Re: M/56/15/HH - 31 Sea Way, Middleton on Sea, PO22 7RZ

Having discussed with our client, we wish to amend our proposal and submit the following substitute plans:

- 14029-03-A (Plans)
- 14039-04-A (Elevations and sections)
- 14039-06-A (Block plan)

ROOF PLAN
1.100

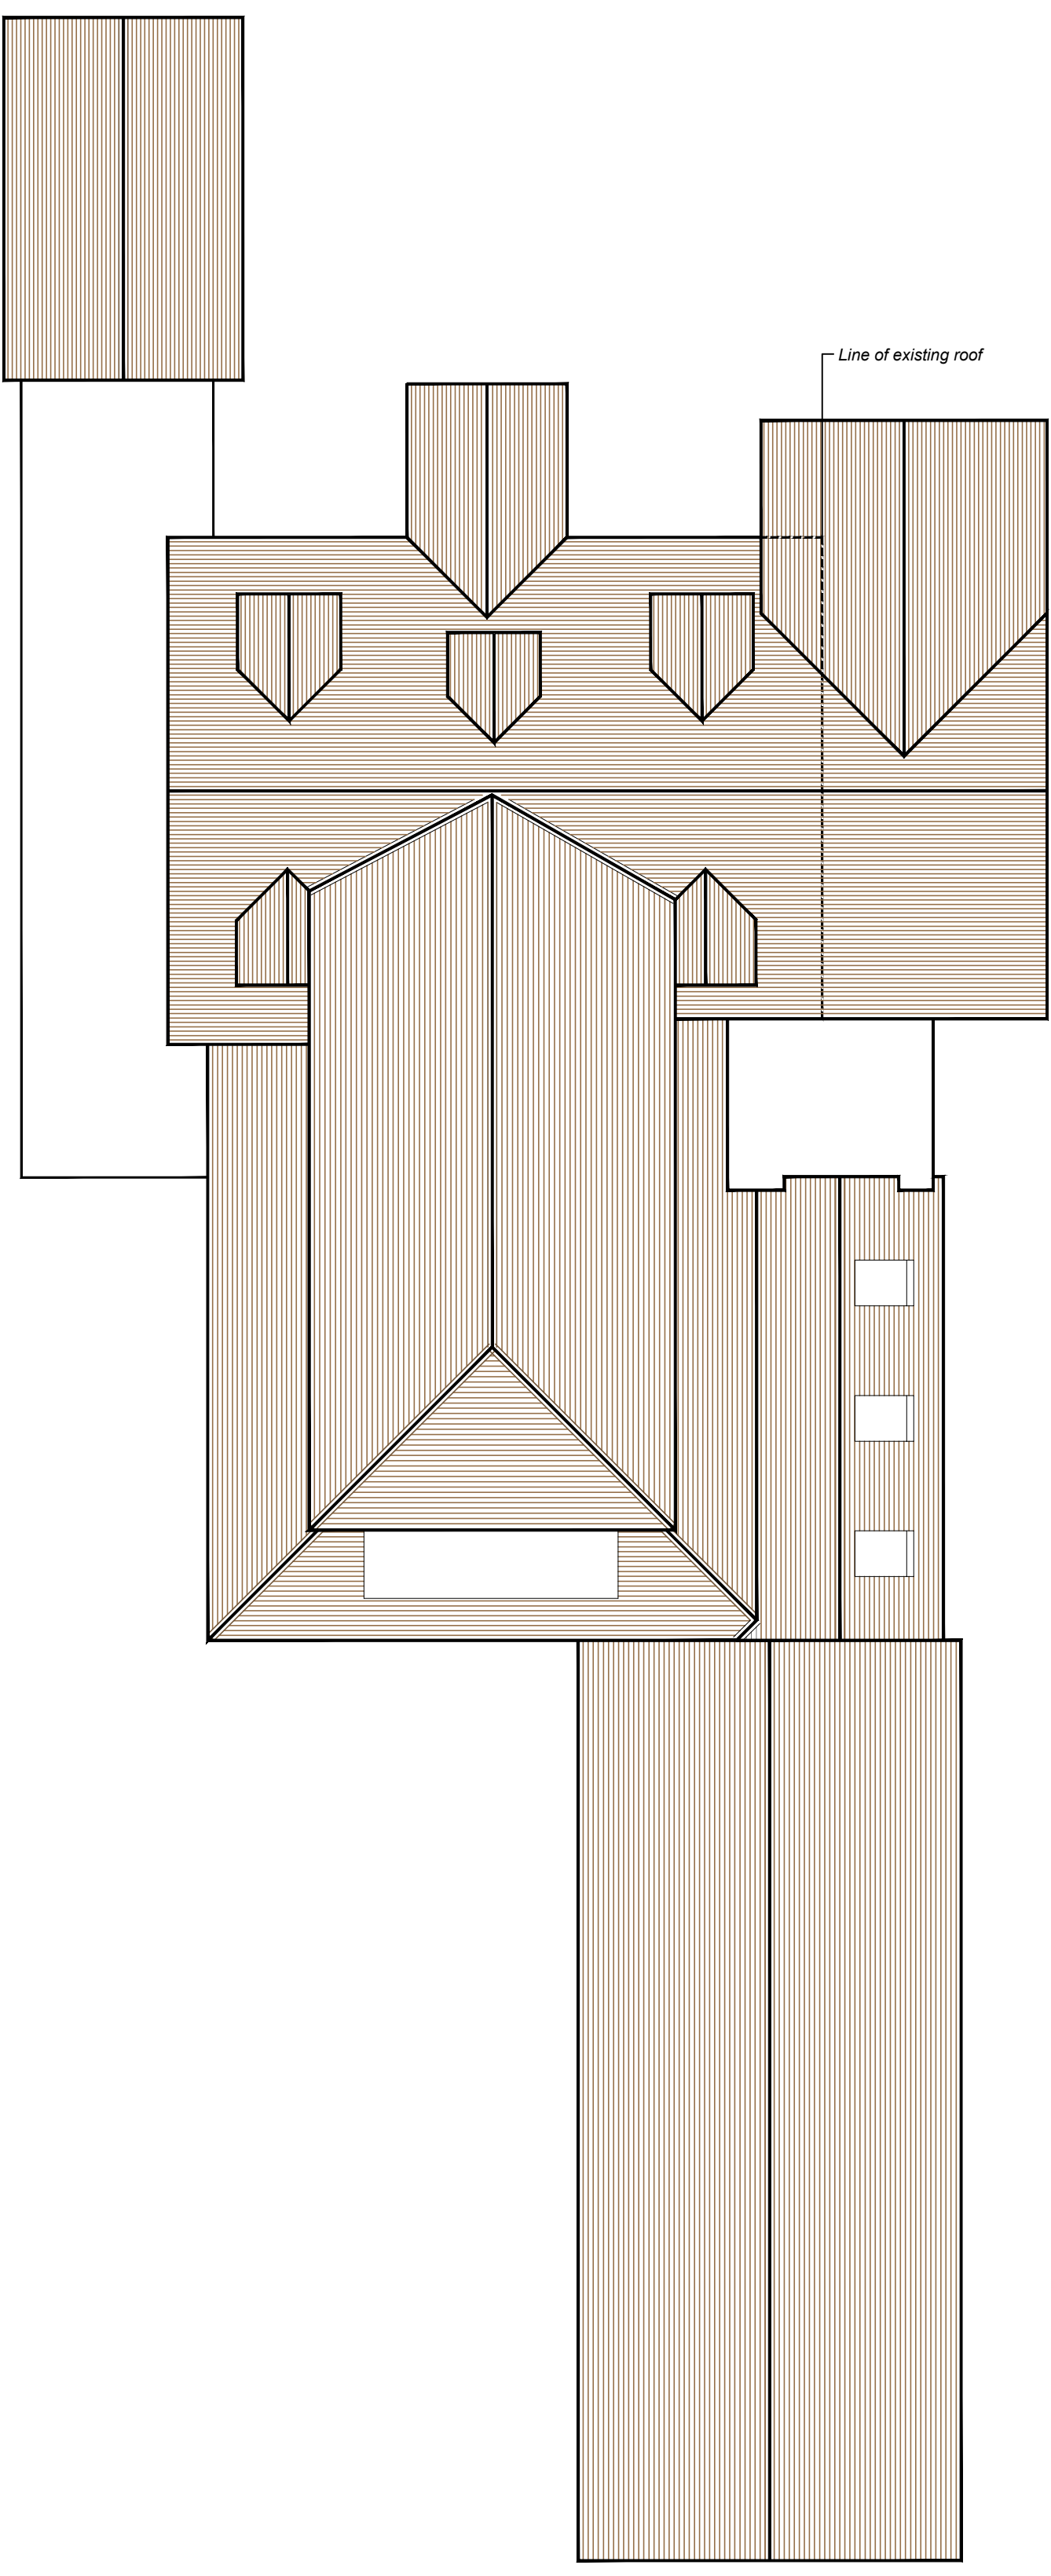
1. Omitting the proposed carport to the front of the property.
2. Reducing the pitch of proposed extension to enclose the existing swimming pool from 31.6° to 25°. This reduces the height of the ridge by 480mm.
This roof is proposed to slope away from the boundary so it does not overpower the boundary with No29 Sea Way. The shrubbery along the boundary between 31 and 29 Sea Way is to be retained which will help screen the proposed extension.
